Our reference: ECM: 9476817  
Contact: Gavin Cherry  
Telephone: (02) 4732 8125

19 March 2021

**Response to Request for Advice on Oakdale West Estate Stage 3 Development  
SSD 9794683**

05 Southern Link Road Frontage  
Typical Street Section - Scale 1:50 @ A1

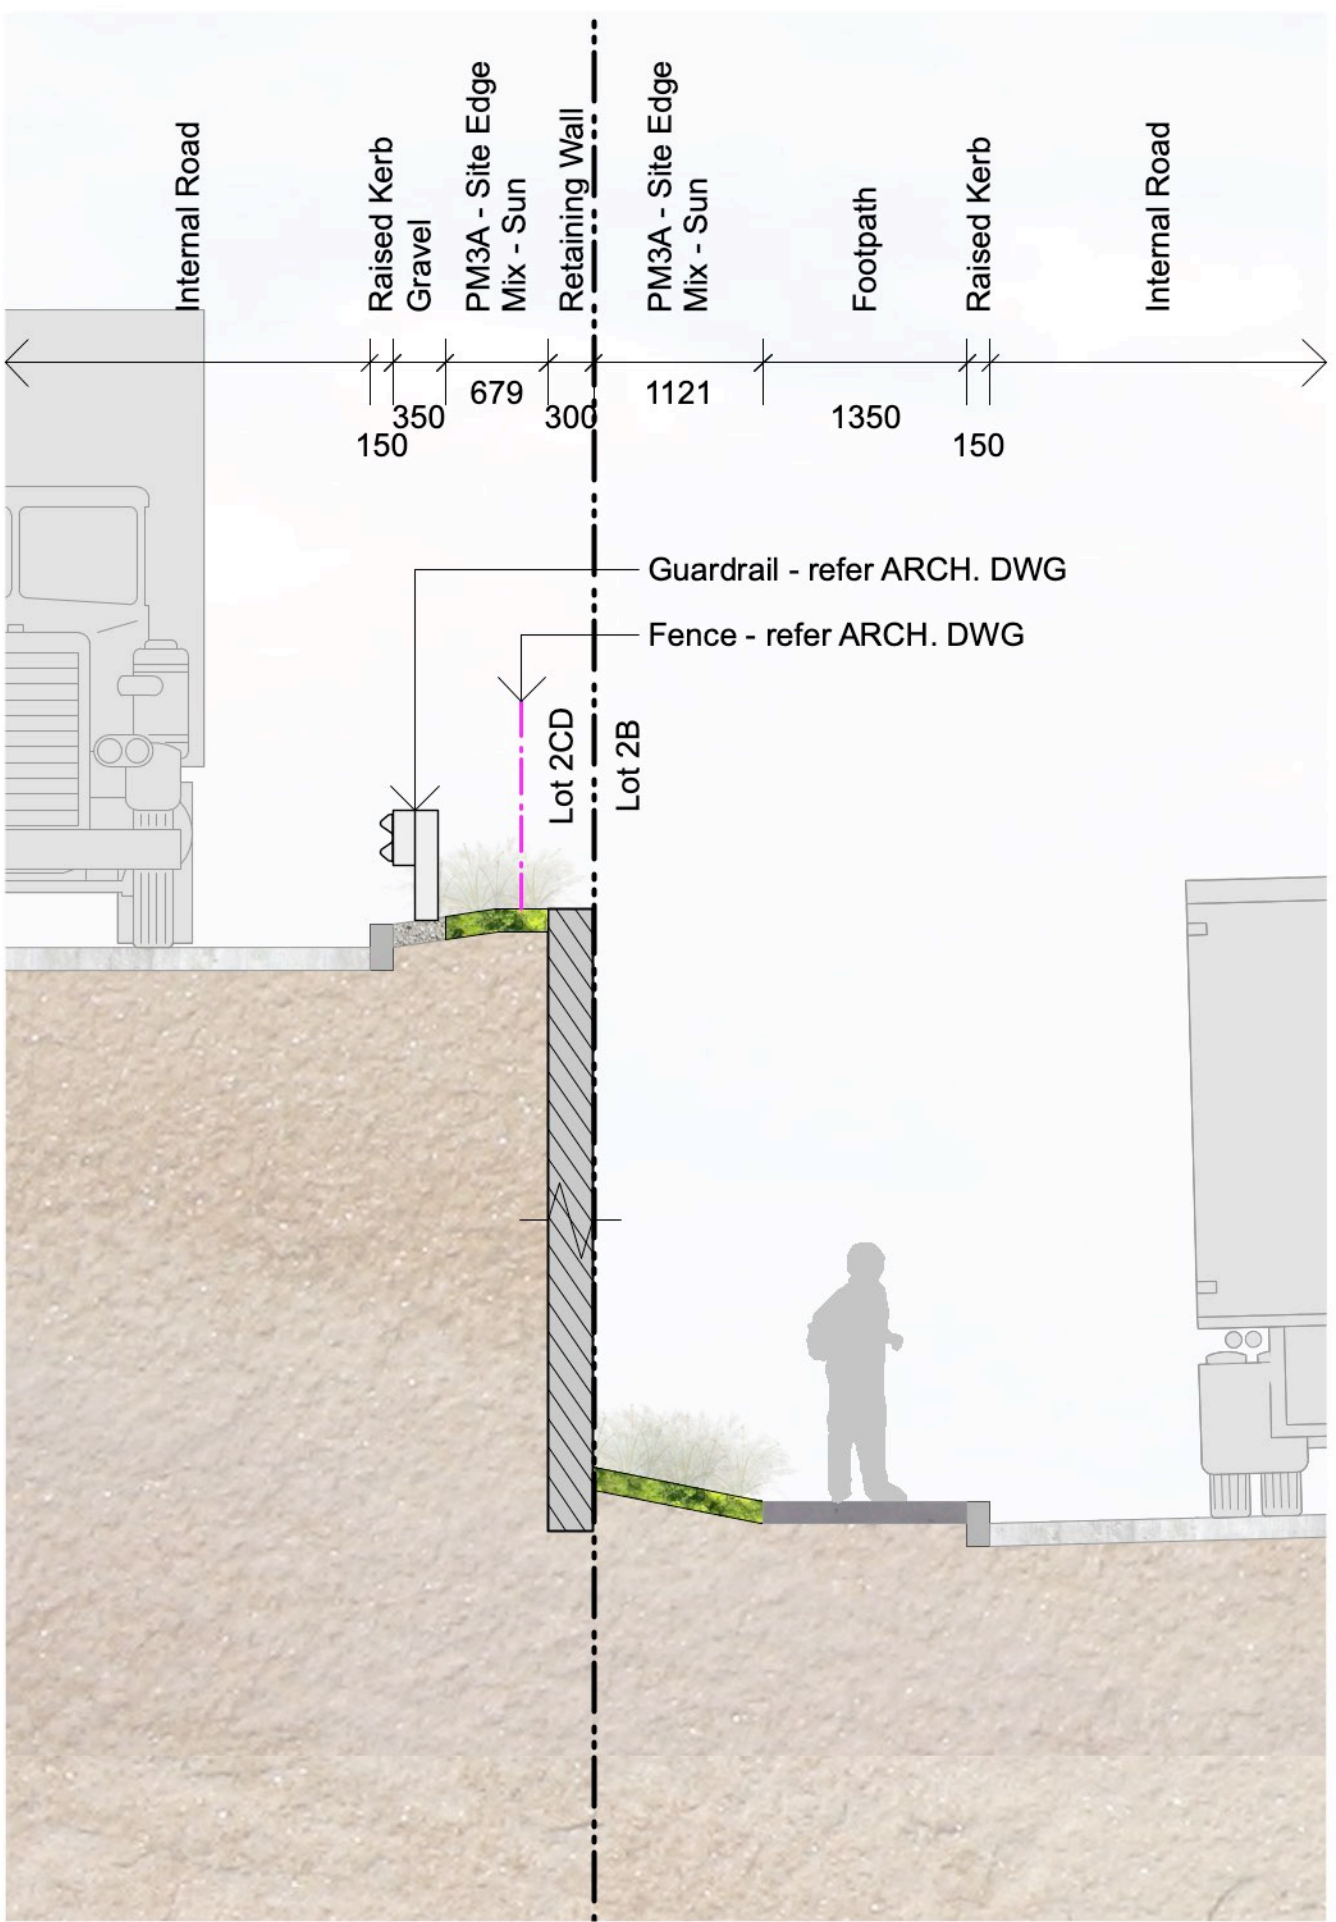
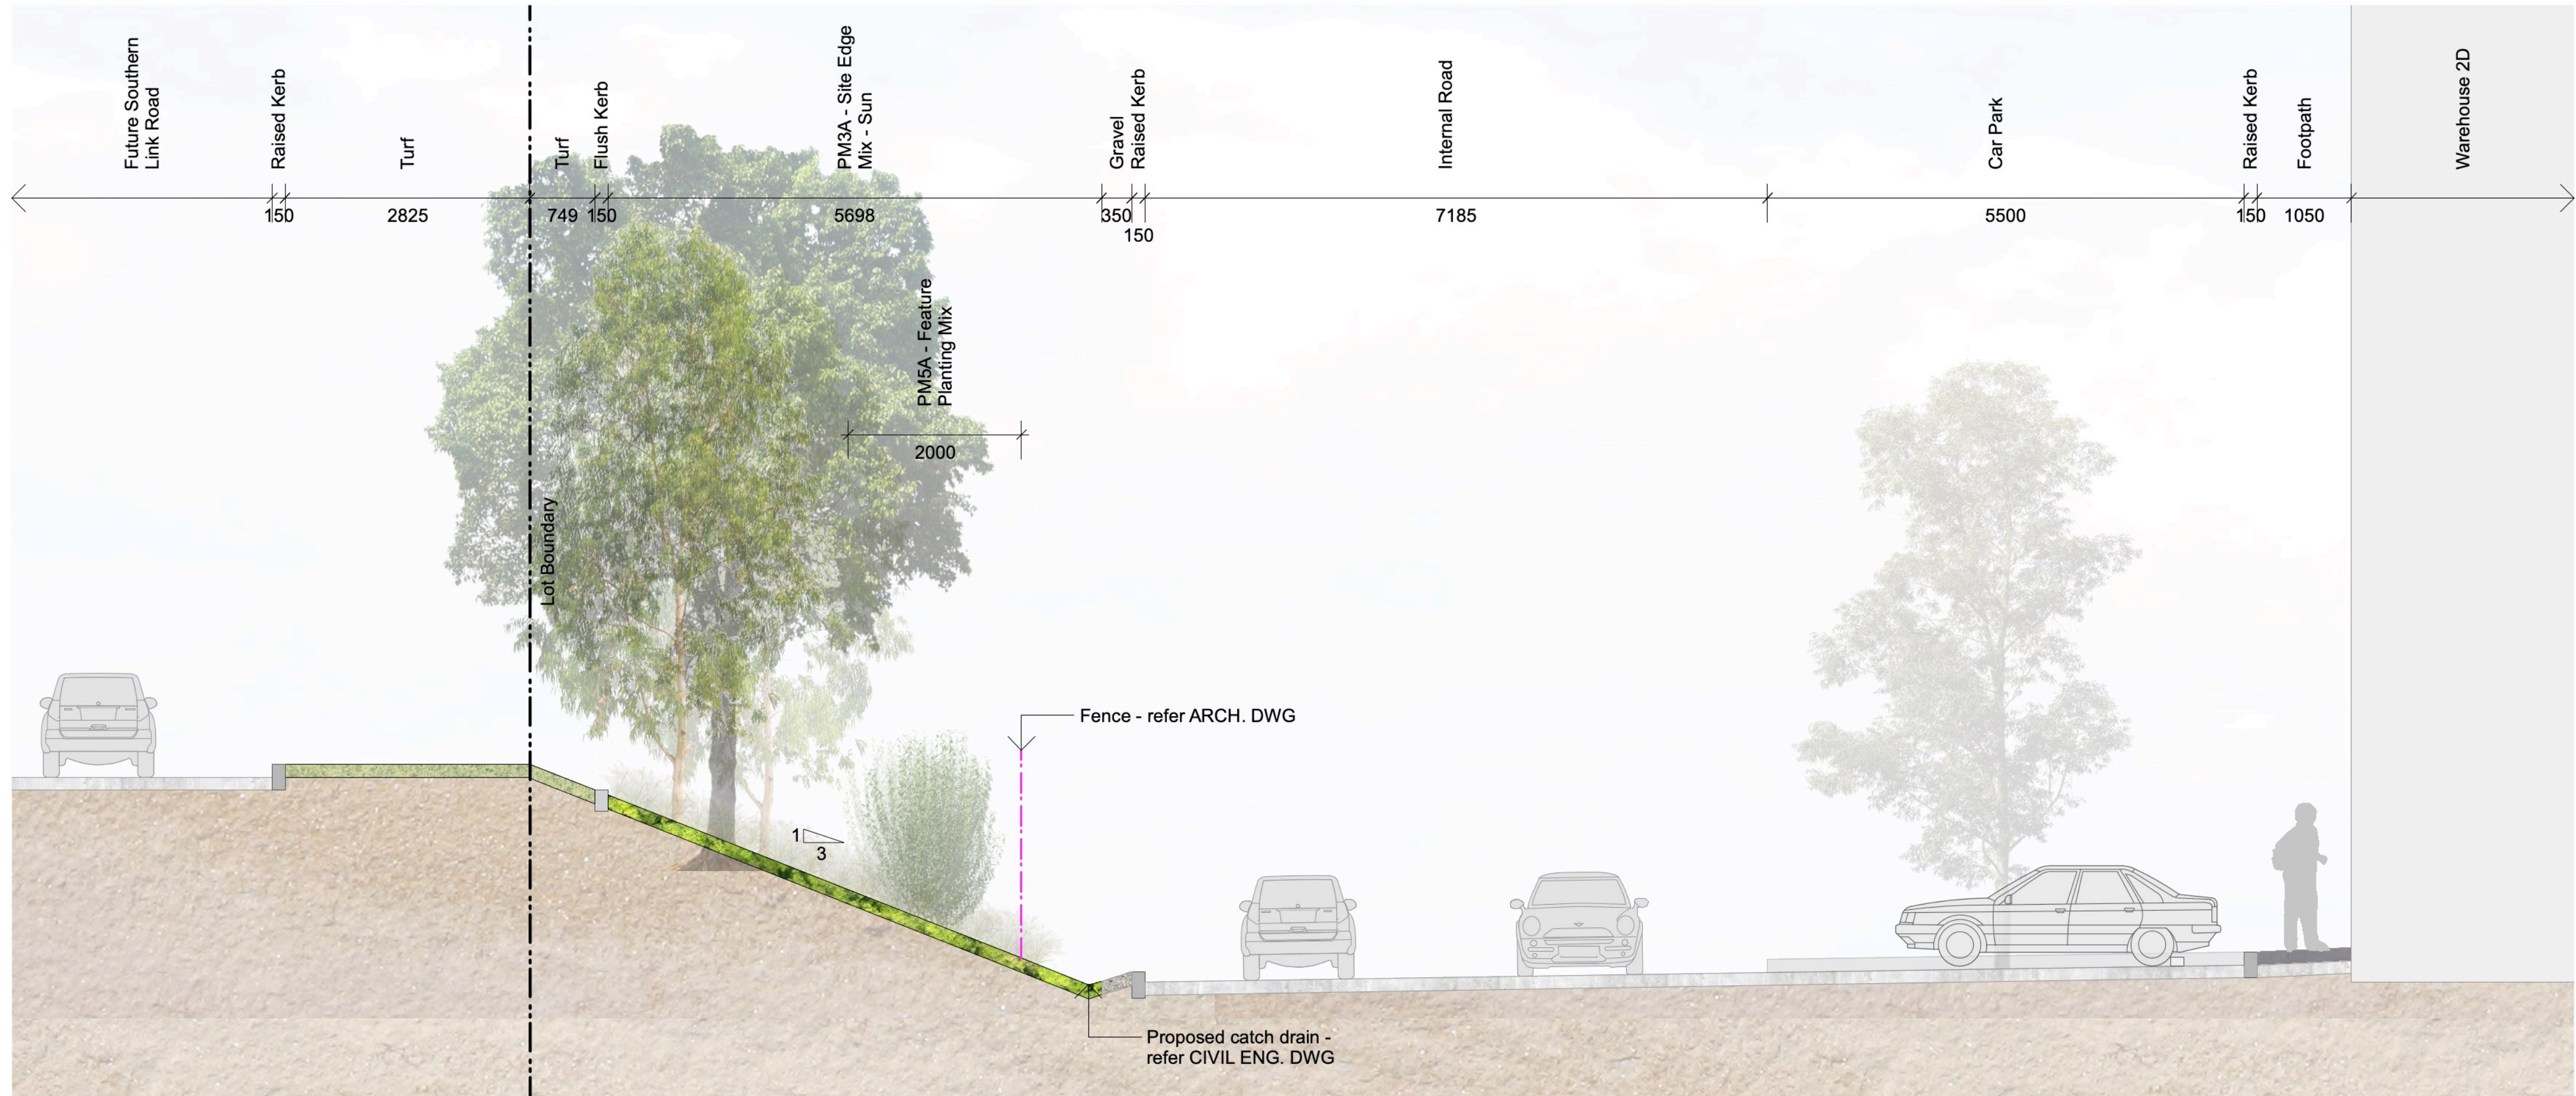
- Documentation submitted indicates discrepancies between sections and plans (ie. retaining walls on Southern Link Rd). The plans require verification to ensure that the landscape plan, landscape sections and architectural drawings are reflecting a consistent built form and streetscape outcome.

- The extent of canopy and density of planting within the setback to the South Link Road is inconsistent with verge treatments along this road corridor. Density and diversity of tree and shrub (medium and tall) species should be increased and retaining walls fully screened so the effect is dense and informal and biodiversity maximised. Tree species are shown as two, yet the number of tree species should be minimum of six. It should also be noted that hedges at this location are not supported by Council's Landscape Architecture Team.
